Intake Comments

**Permit #2211-123, Hatley Residence**

See below in response to review comments dated November 23, 2022.

NOTE #1:
PROVIDE 3/4" OSB/ PLYWOOD SHEATHING FASTENED PER TYP. EXT. WALL SHTG. SPEC. (SEE NOTES)

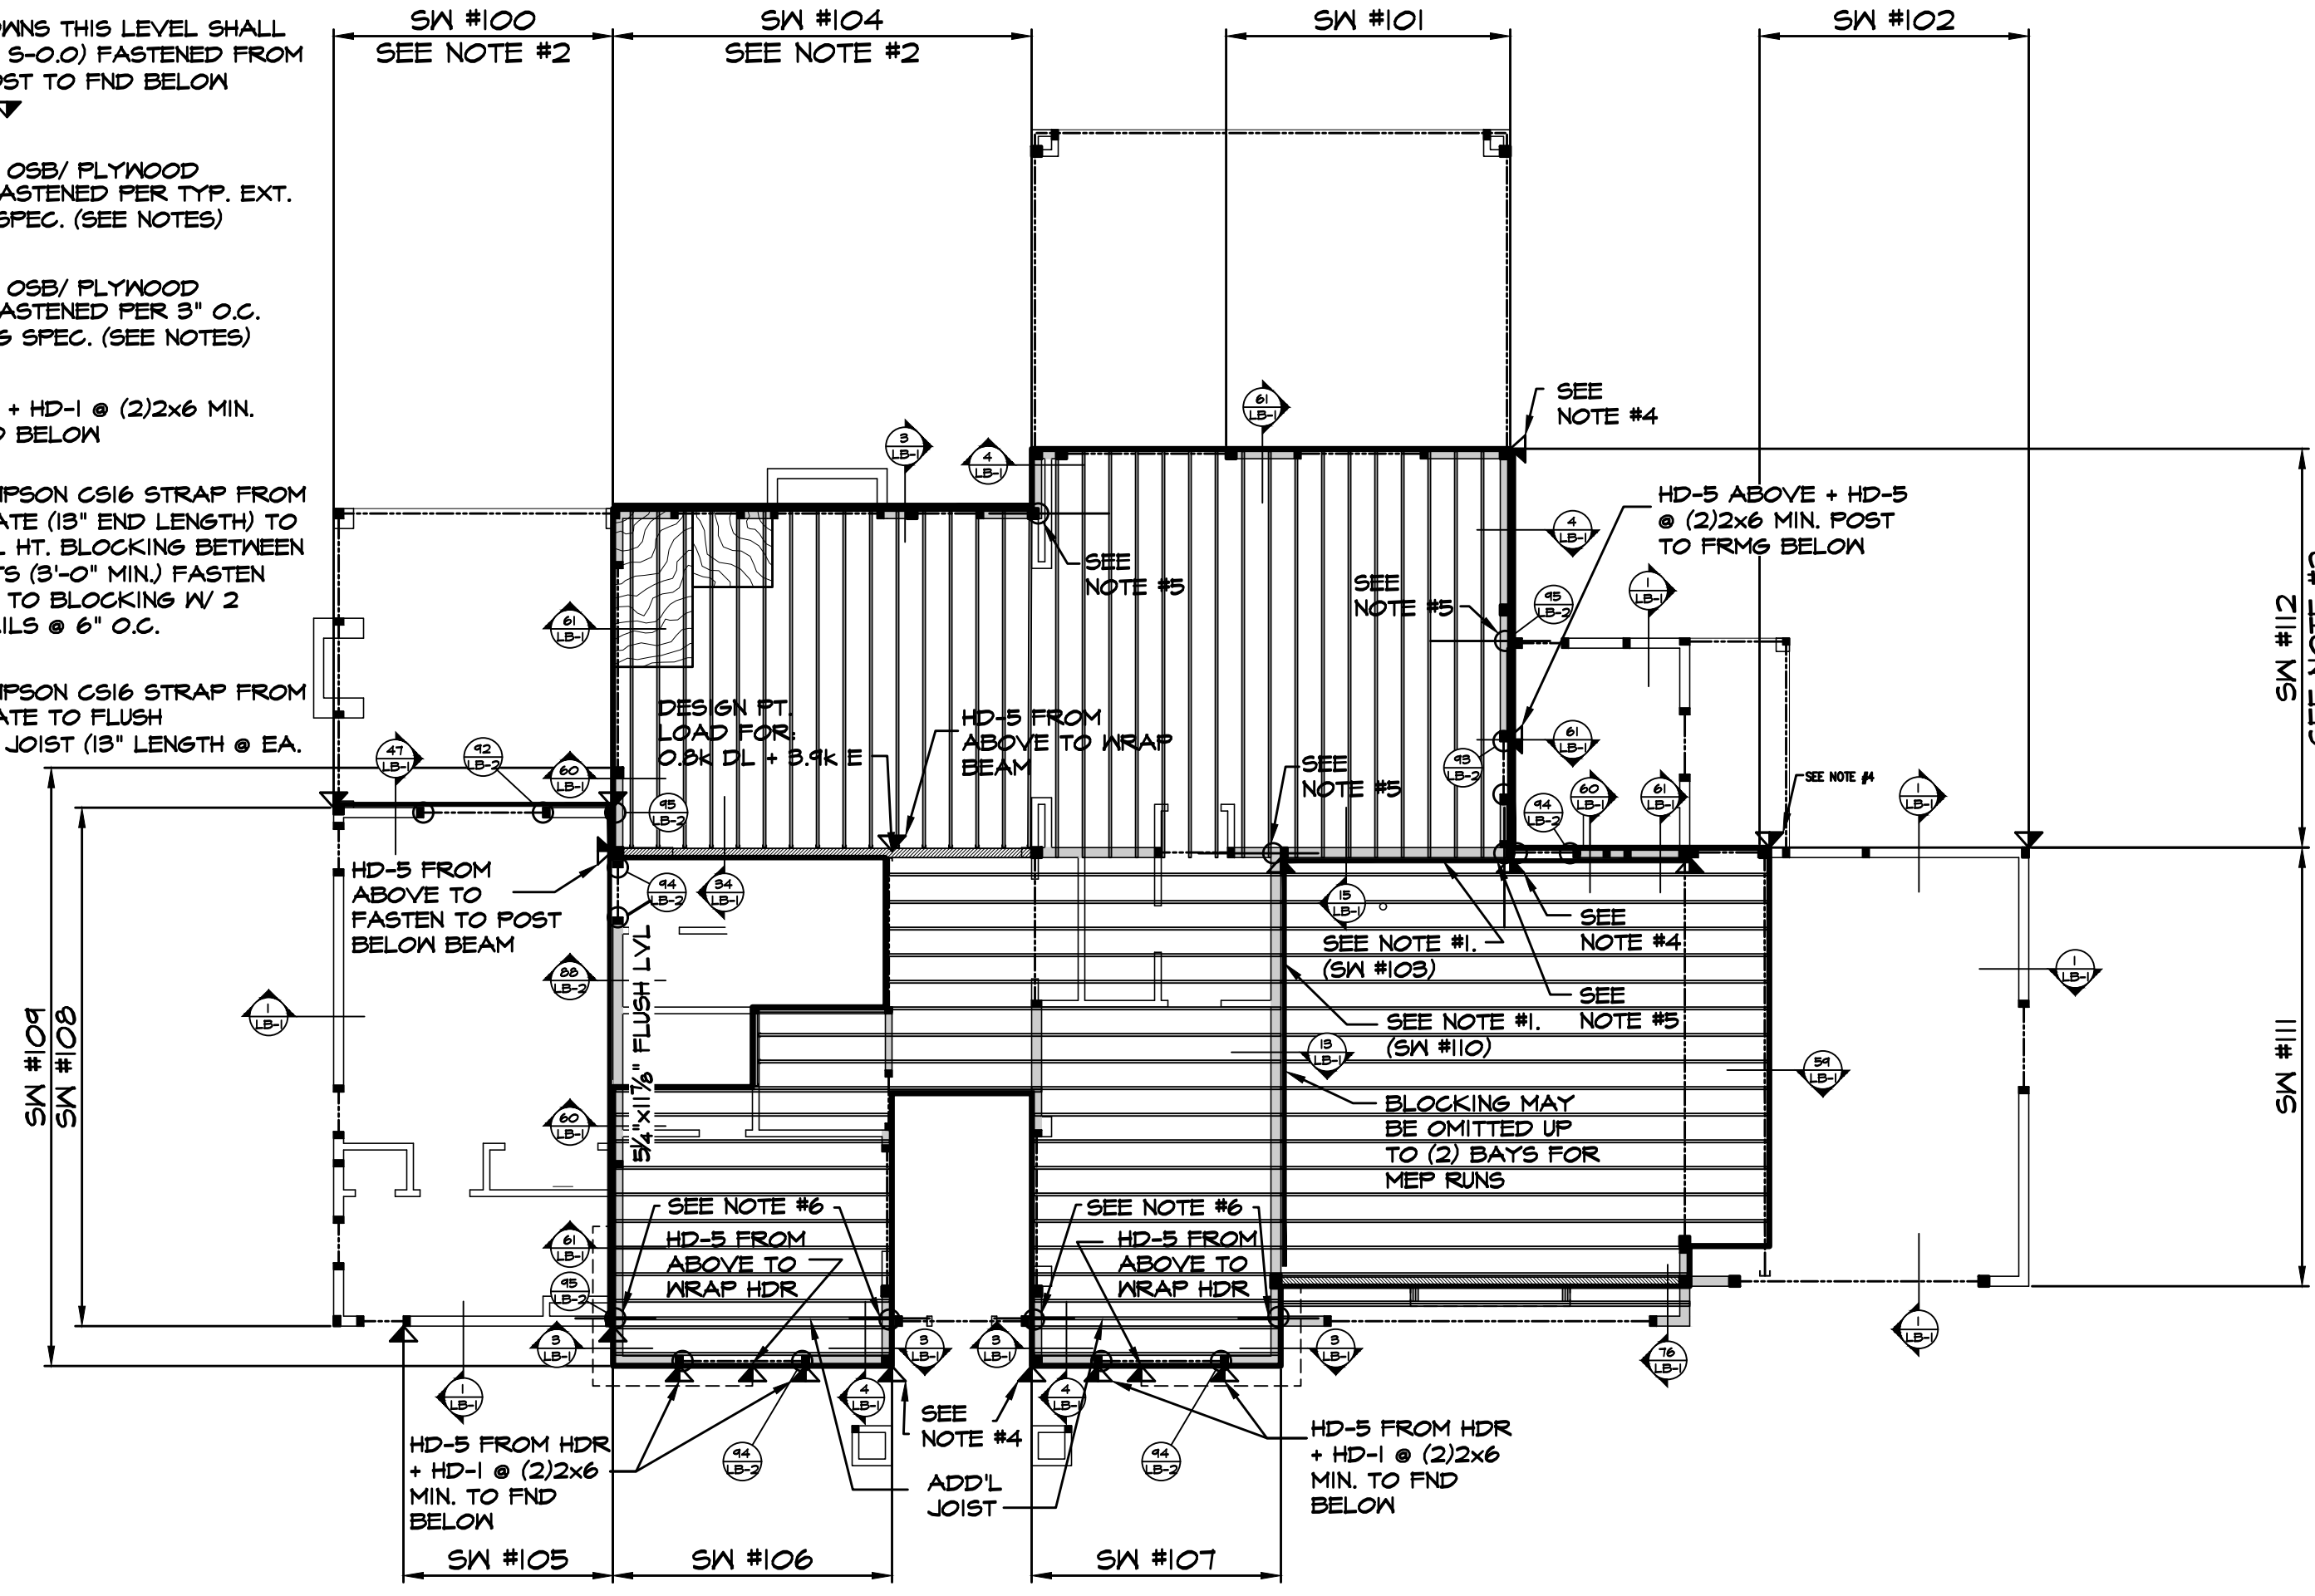
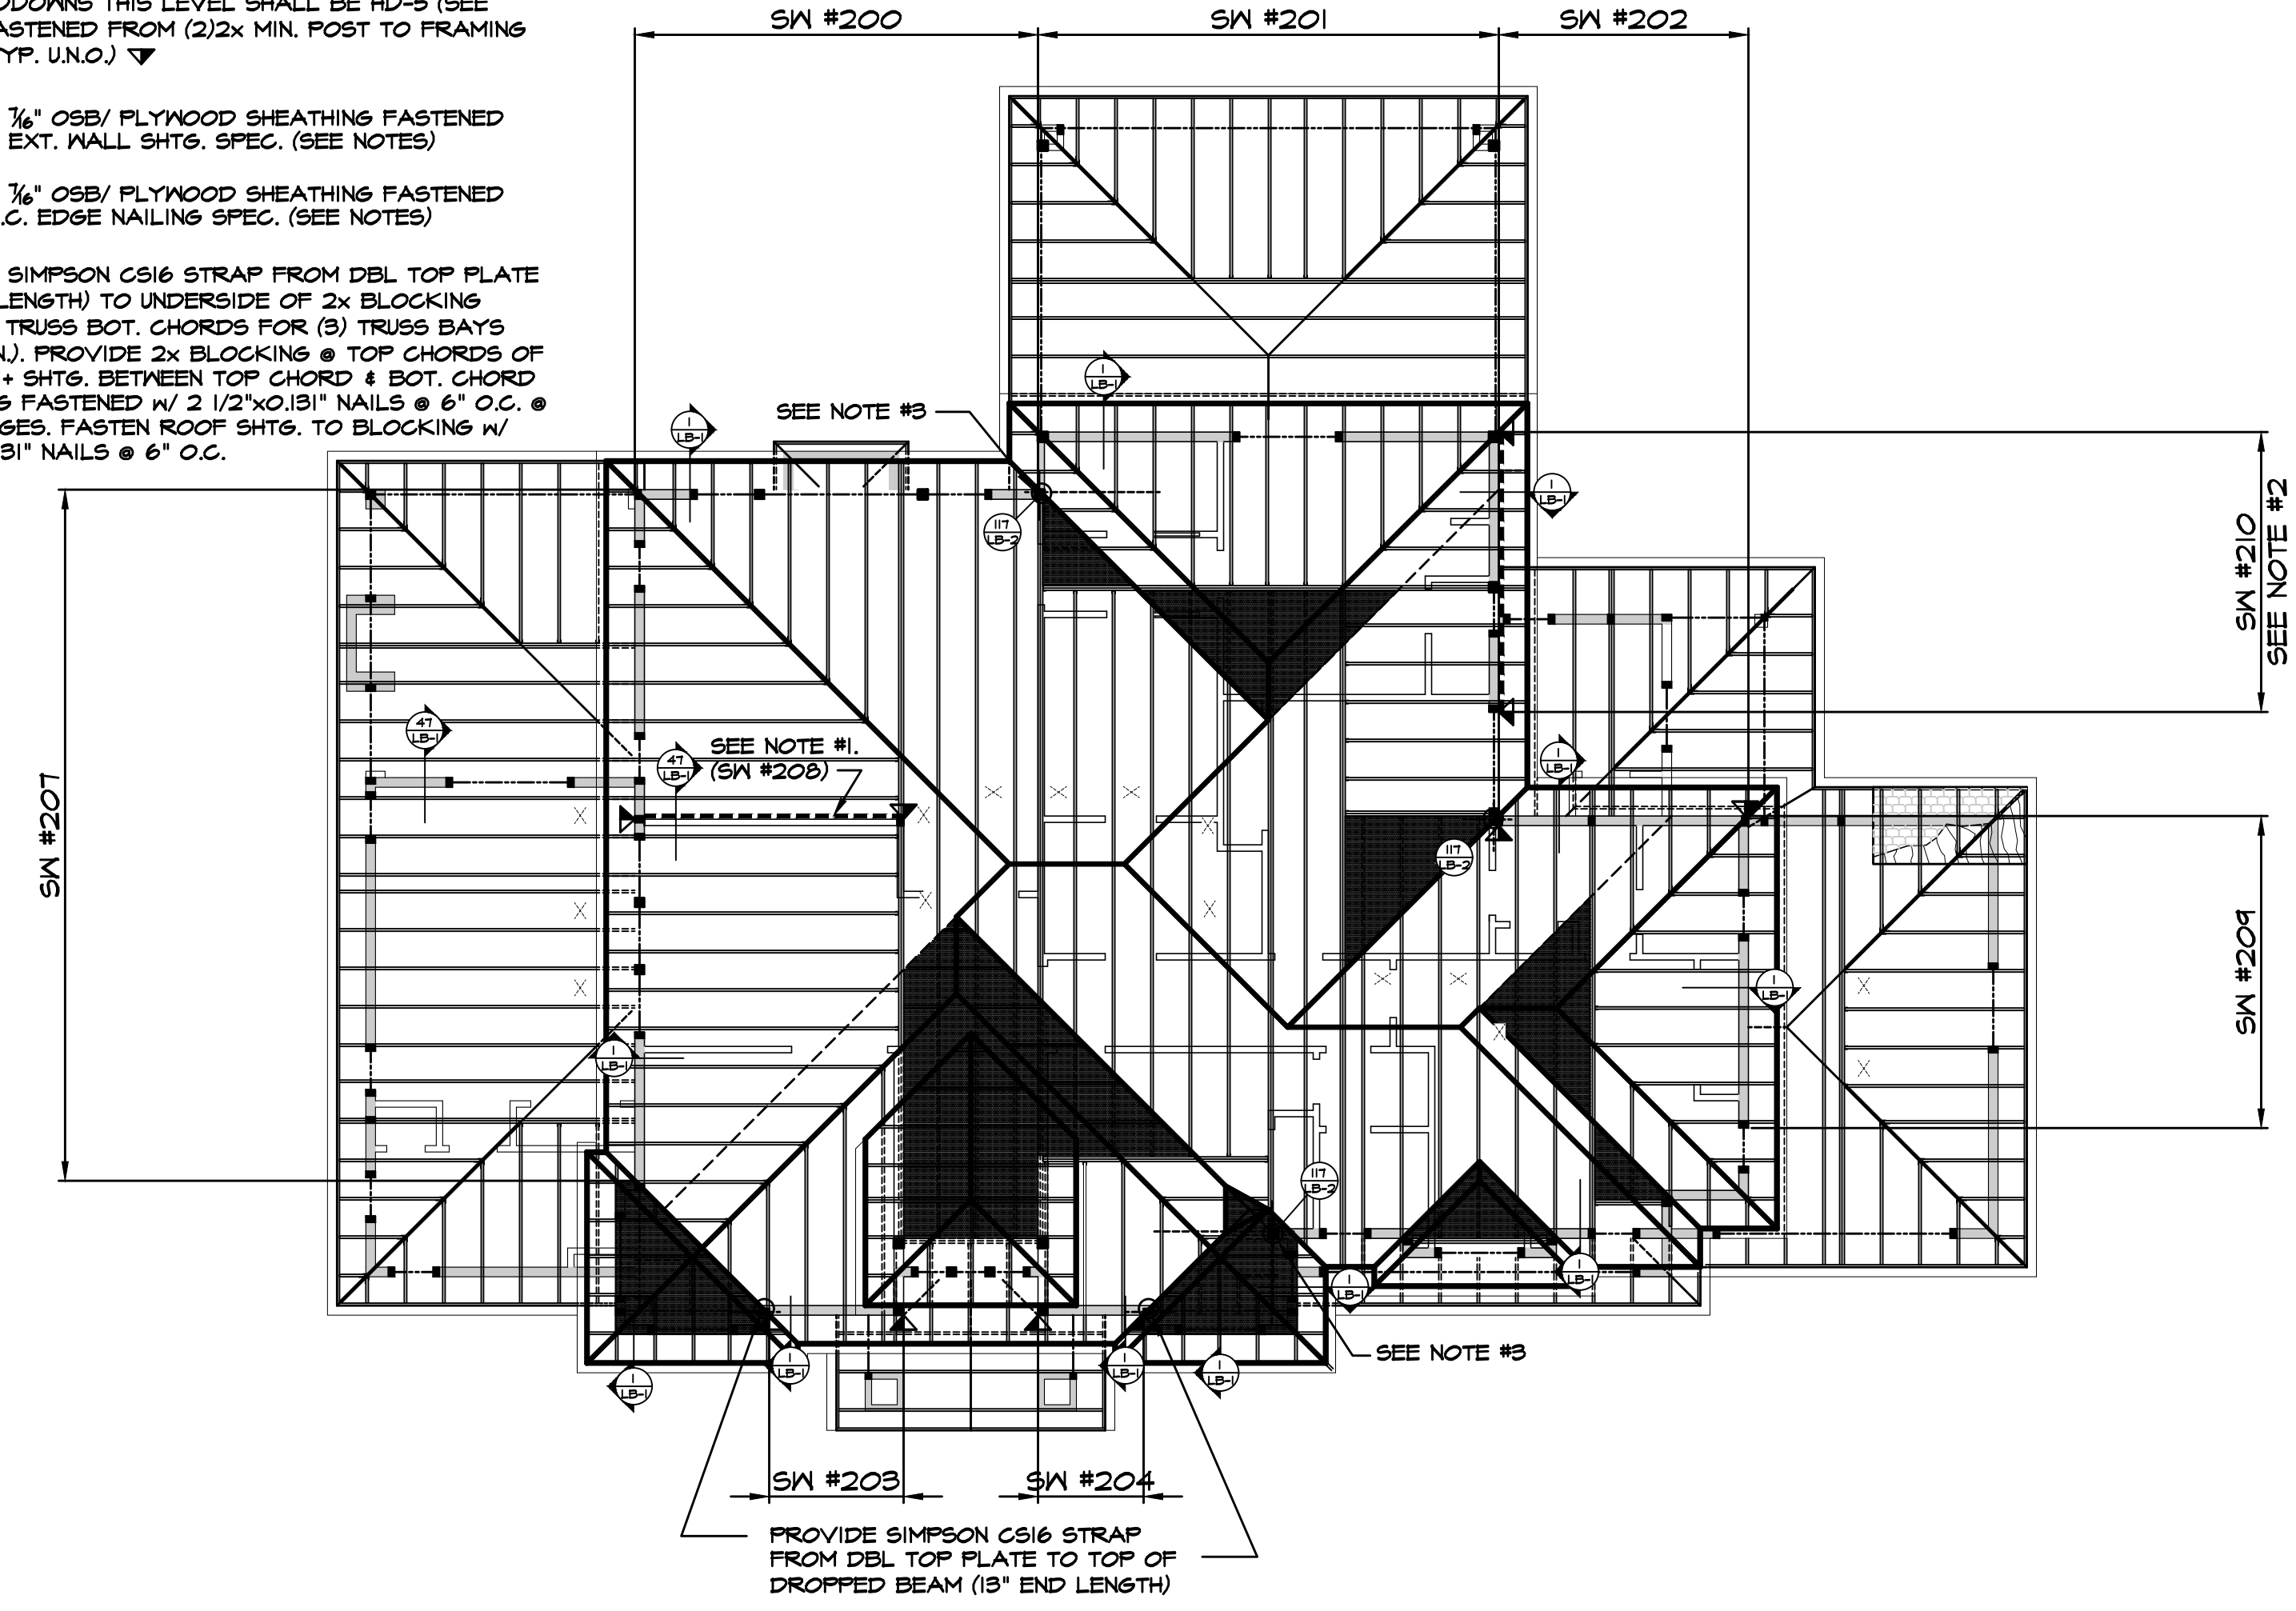
1. The lateral calculations by Mulhern + Kulp were previously provided to the client, but may have been omitted from the submittal. The seismic design criteria is shown on sheet S-0.0, and was derived from the attached ASCE hazard report.
2. Key plans for the shear walls are provided on sheets 4 and 5 in the lateral calculation packet by Mulhern + Kulp. Key plans for the gravity framing are provided on the last pages of the gravity calculations.
